From: Neil Whitton
Sent: 08 November 2021 10:48
To: Caroline Ford
Cc: DC Support
Subject: 21/03558/OUT - Land On The North East Side Of, Gavray Drive, Bicester, Oxfordshire

Environmental Protection has the following response to this application as presented:

(see Drawing No. 239\_P14-Building Heights Parameter Plan)

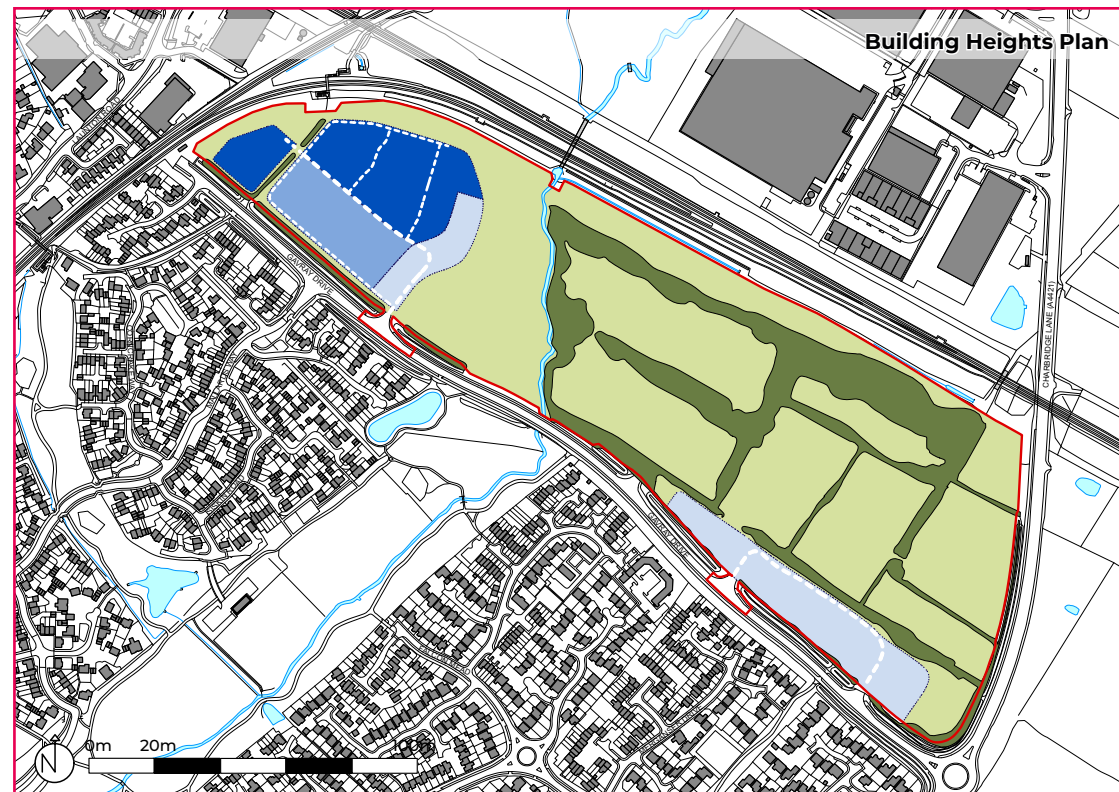
2. Paras 10.6.10 and 10.6.11 states that the calculations assume that a noise barrier will be installed to the north eastern boundary of the site therefore this should be installed and approved by the LPA prior to the first occupation of any residential property on the site.
